From: Anita Gardner
Sent: 14 December 2012 14:21
To: [REDACTED]
Subject: FW: Brookview Nursery WA/62/12/CLE
Attachments: BROOKVIEW - STRIDES.pdf

SITE BLOCK PLAN @ 1:500
Ordnance Survey, (c) Crown Copyright 2012. All rights reserved. Licence number 100020449

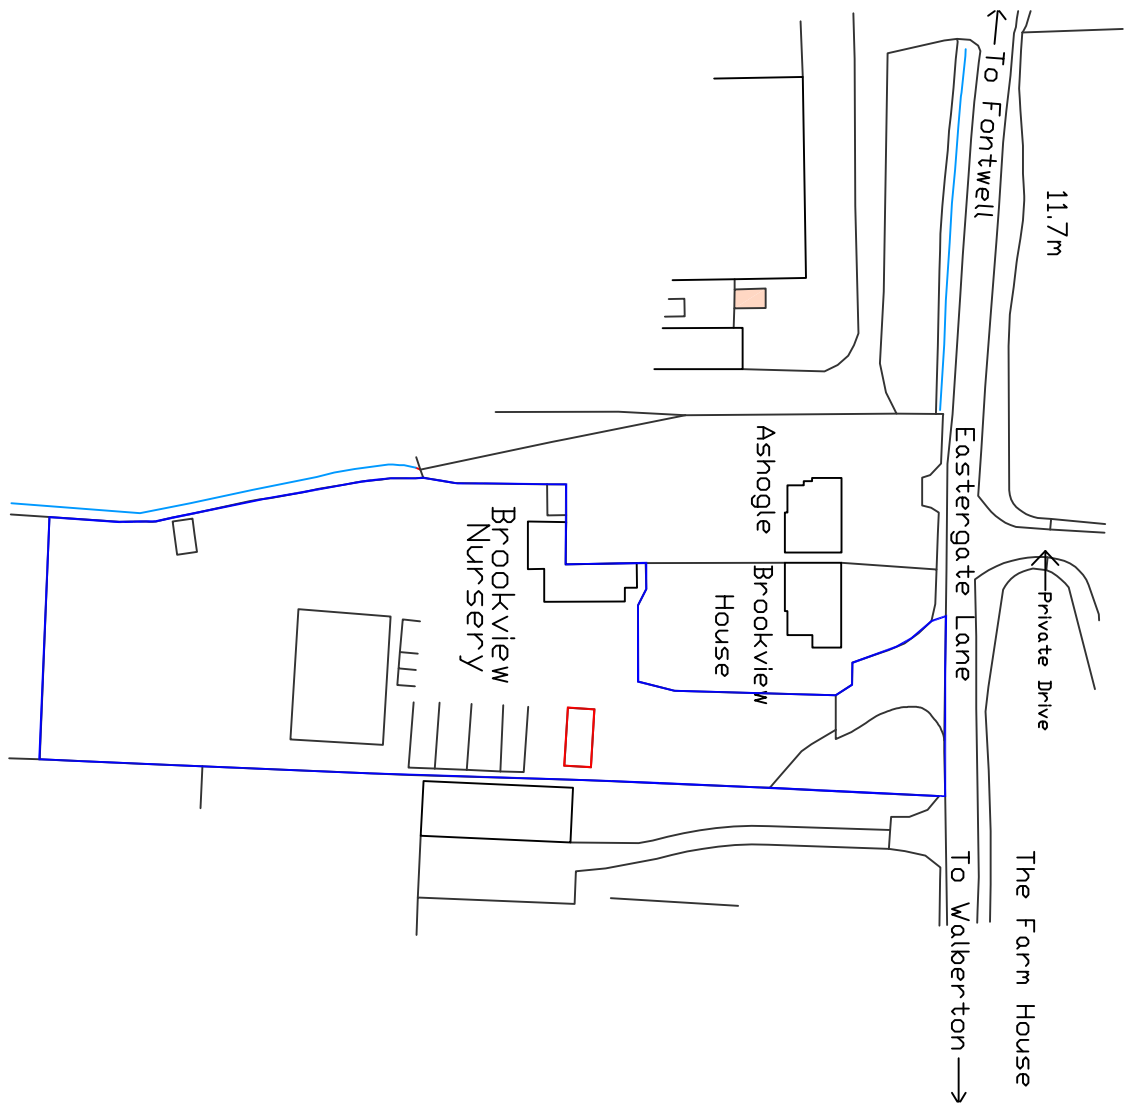
I acknowledge receipt of the revised plan. Before I get it printed off and substituted I am questioning why the derelict former plant store with windbreak round is included within the site. Has this area been used as part of the aggregate business or does it relate solely to the landscaping use? If this is the case it should be deleted from the red edge too.

Please find attached an amended plan omitting the plat store from the red boundary.
